Alder Street

Jeff Tarling <jst@portlandmaine.gov>
To: Jean Fraser <jf@portlandmaine.gov>

Wed, Aug 3, 2016 at 10:36 AM

**LANDSCAPE PLAN**

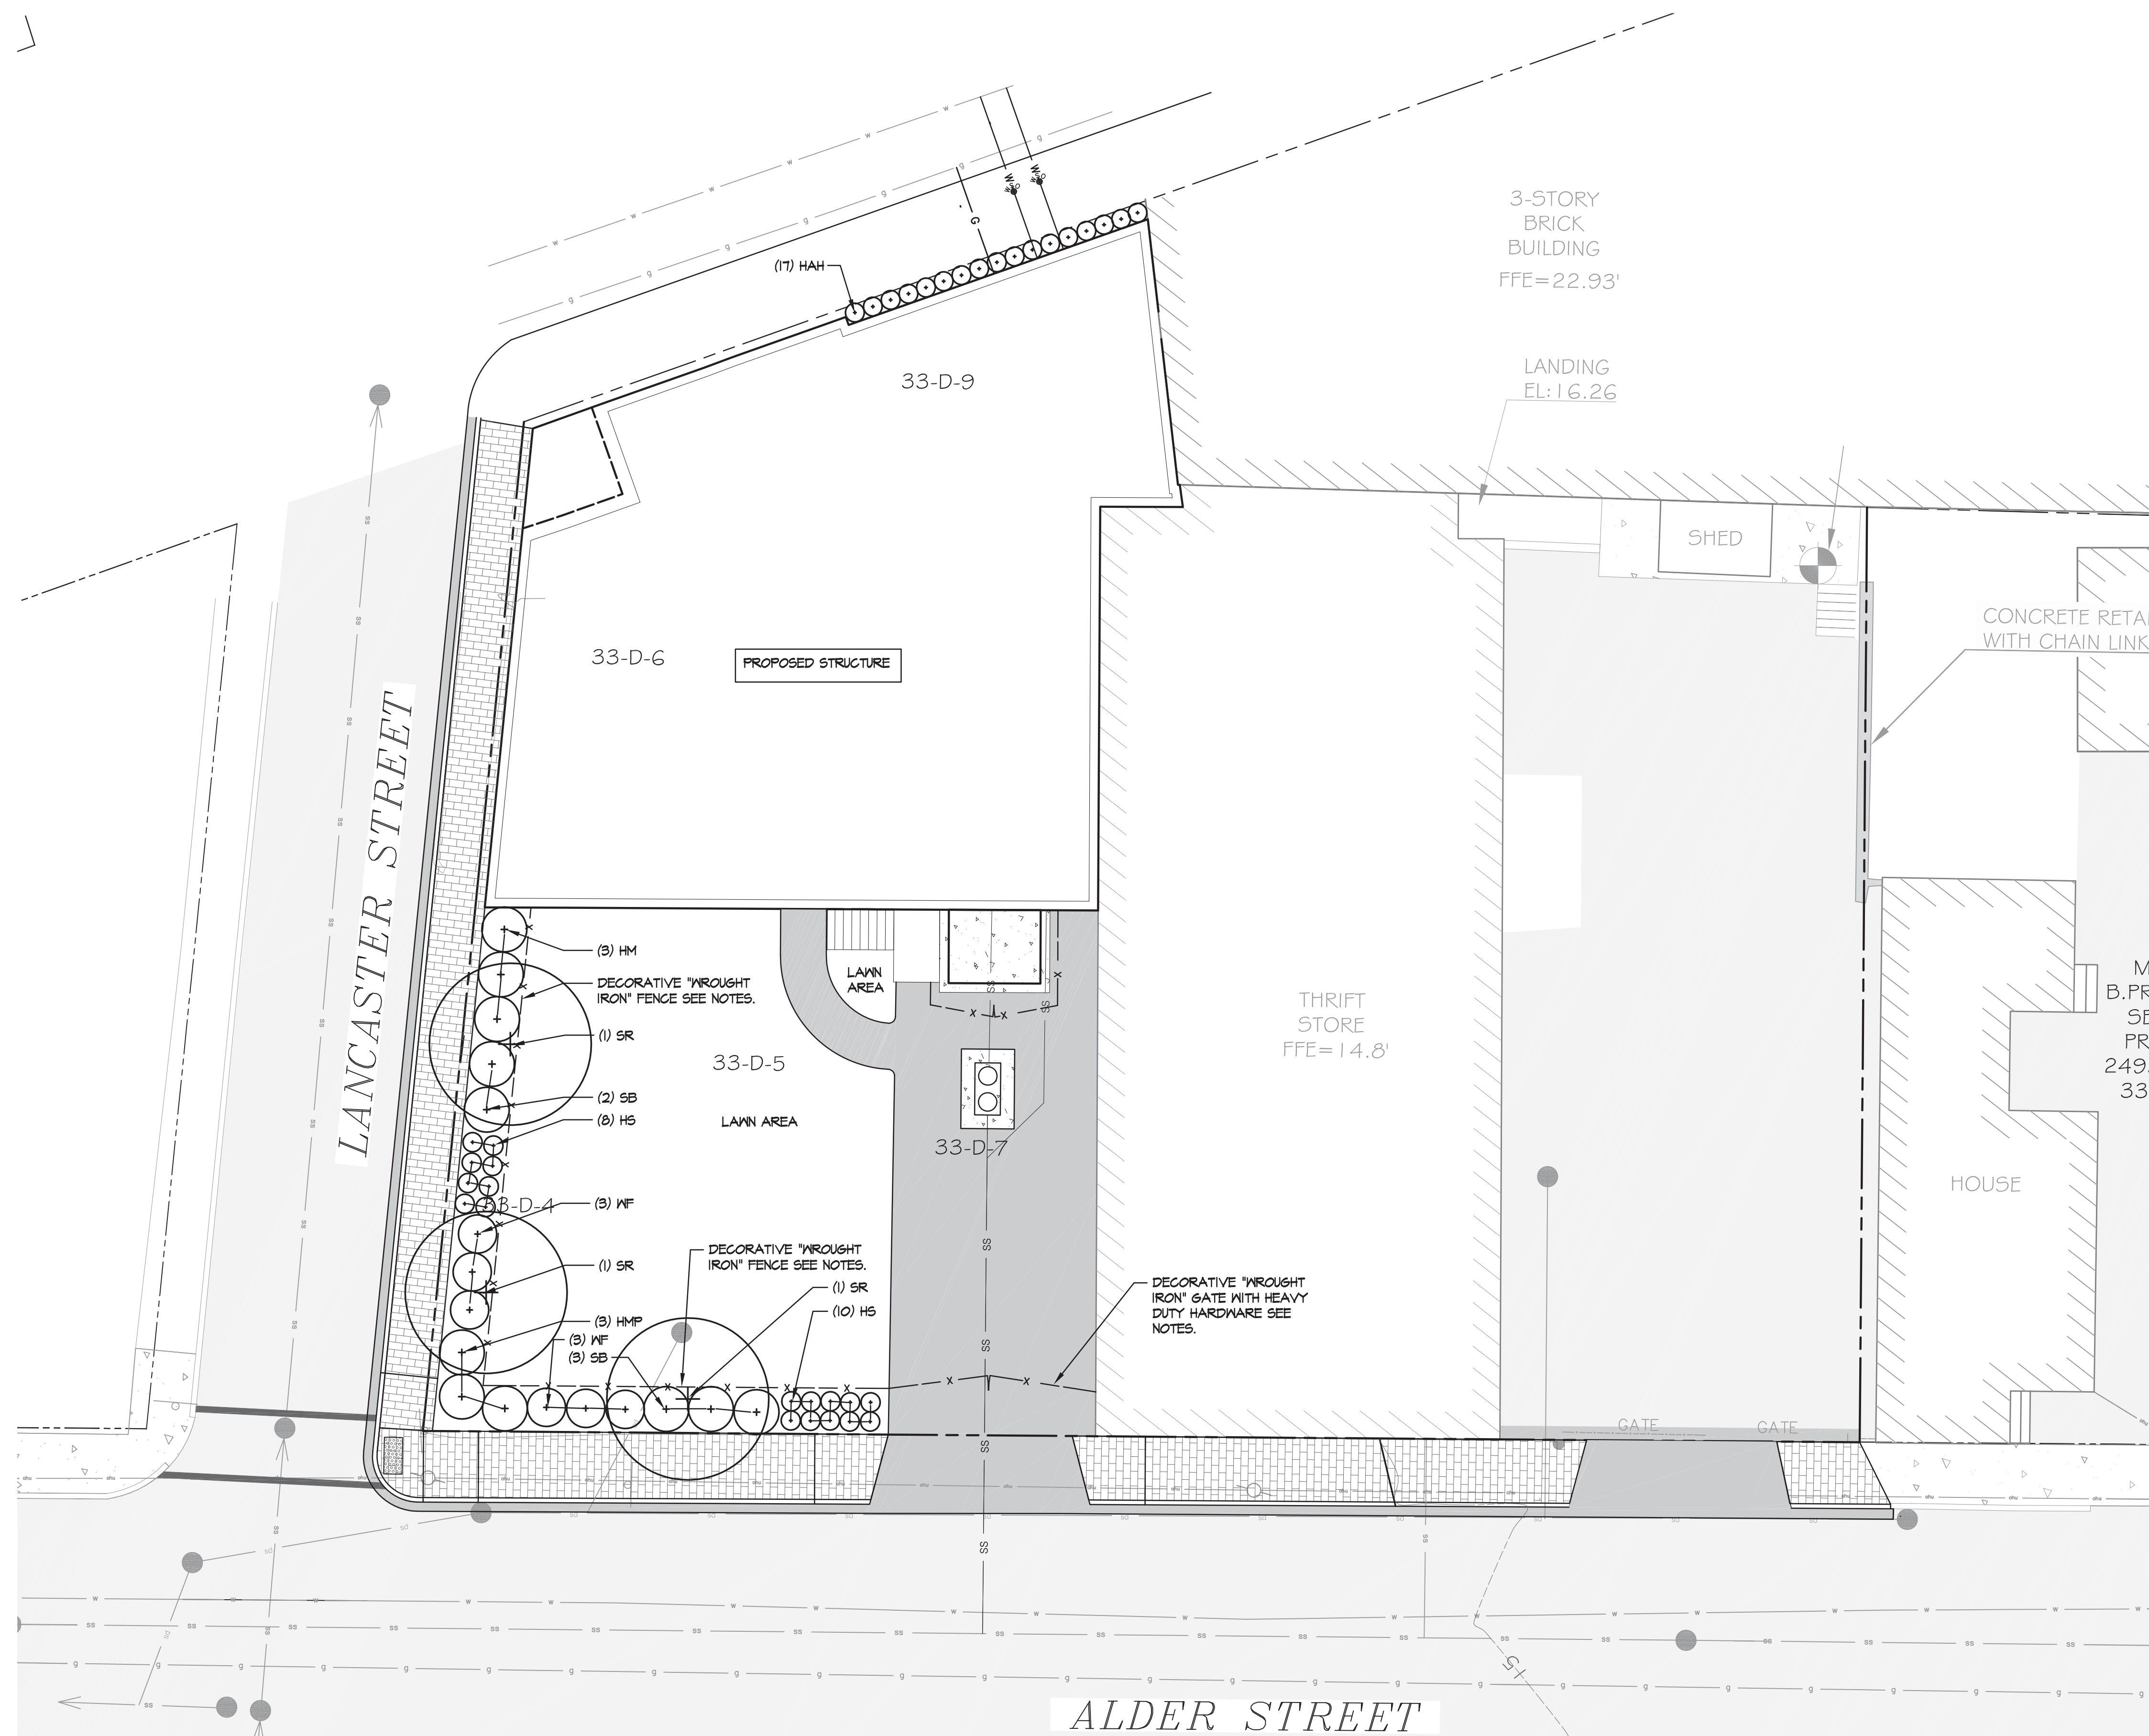
The revised landscape plan looks good for the proposed project. Overall a big improvement for this site and corner. The landscape plan consists of a tree & shrub boarder near the sidewalk edge, ornamental iron fence separating the sidewalk and landscape. Fencing ha been added to screen the dumpster.
